24 December 2021

Planning Application Number 2021/91914

Drawing **Proposed Site Layout**

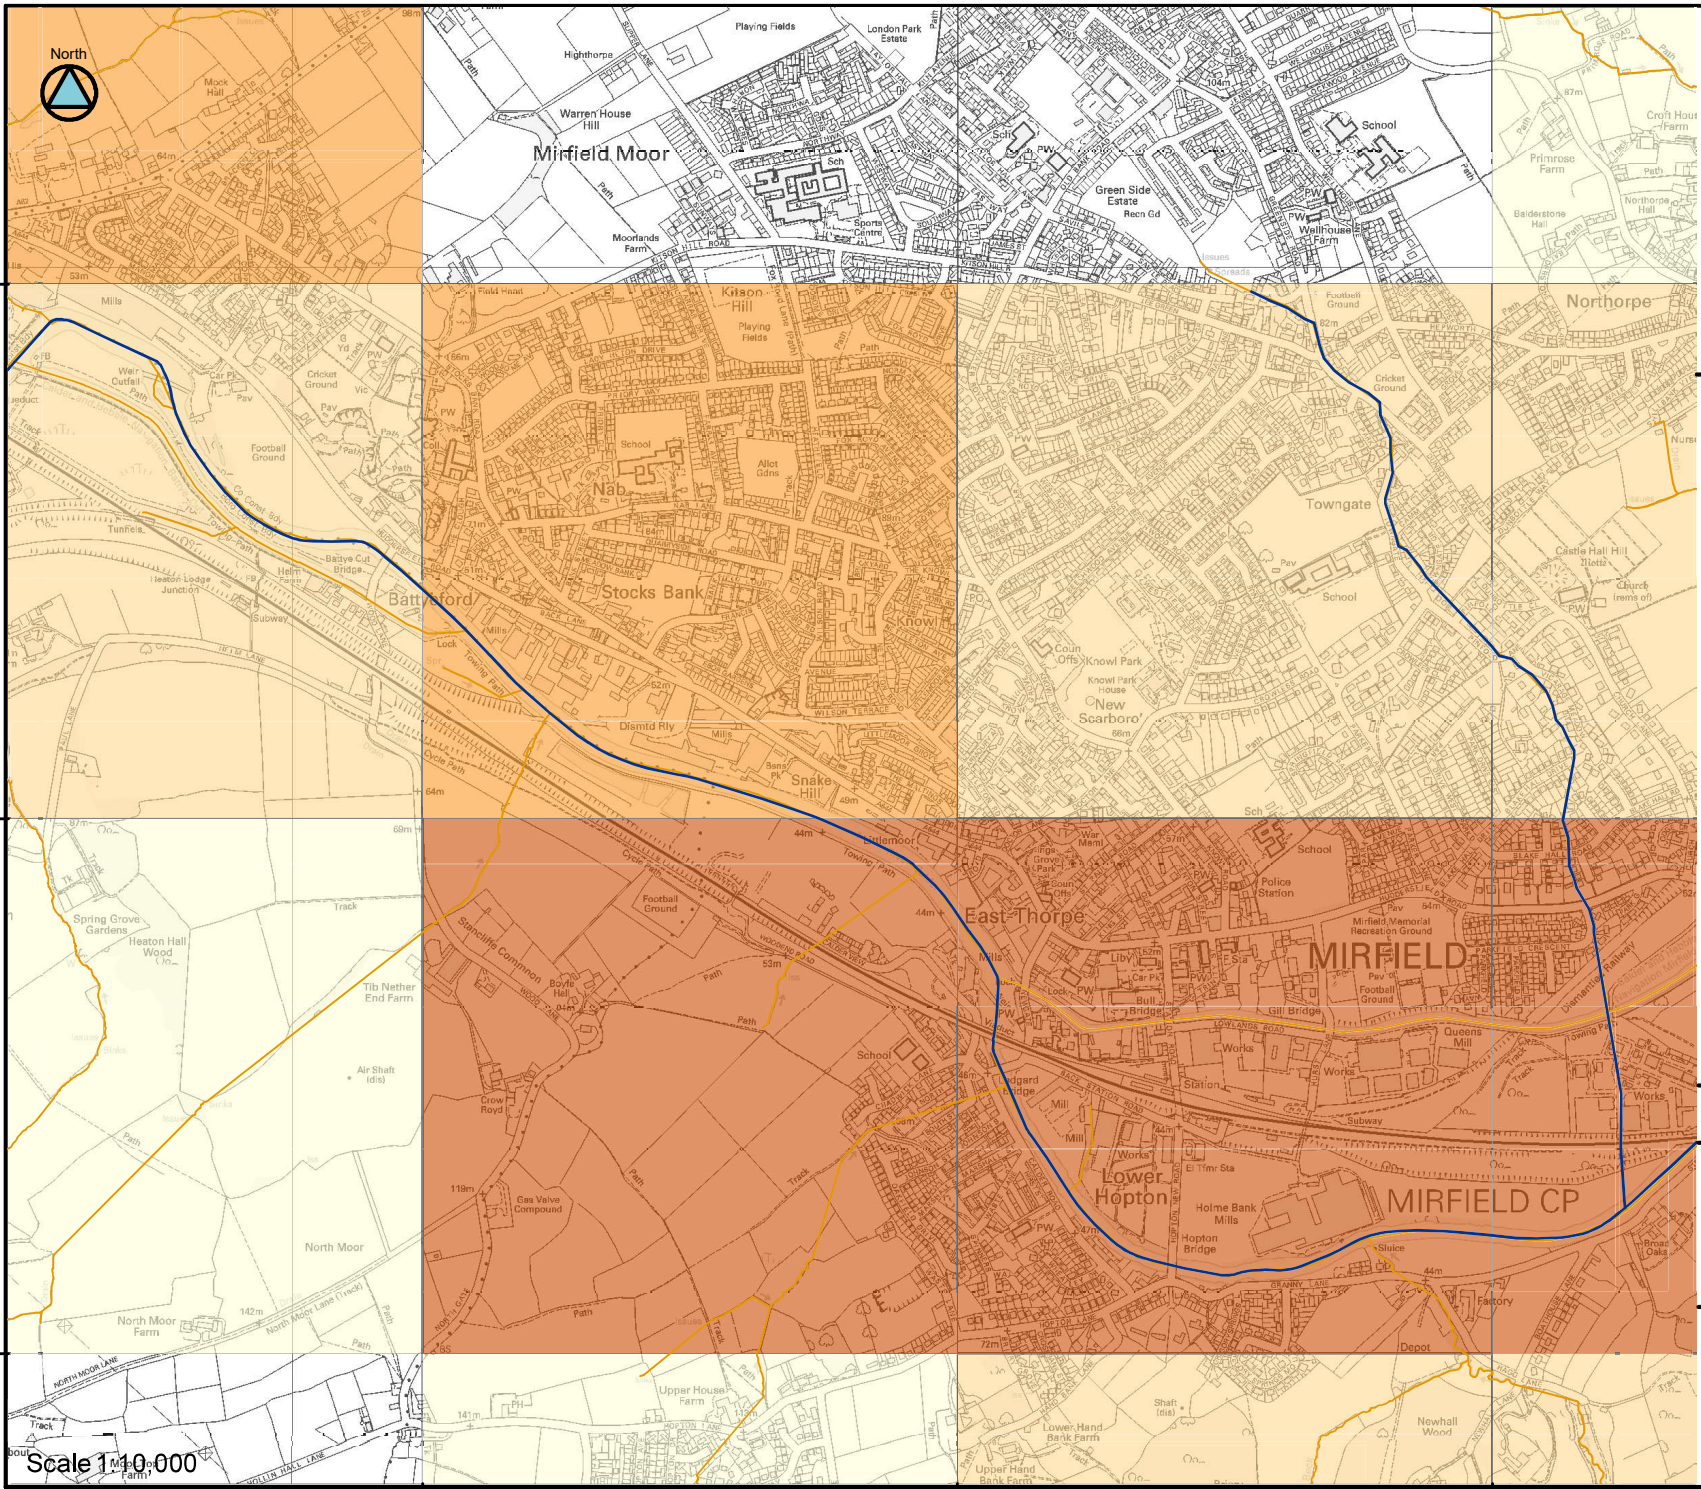
The new plans (which are a remake of the original plan) are still cramming the houses into the confined space, to such an extent that the open space grassland has disappeared. The houses have got insufficient parking for themselves and none for visitors. Units 1 and 2 are very poorly located, they are just squeezed into the narrow entrance. They have little or no space around them and obstruct what should have been an open gateway to a more sympathetic site. The units on the south side of the development are squashed between the railway banking, boundaries and present houses, a real blockage of views and landscape. This tells us that the site is to access money and not enhance the village.
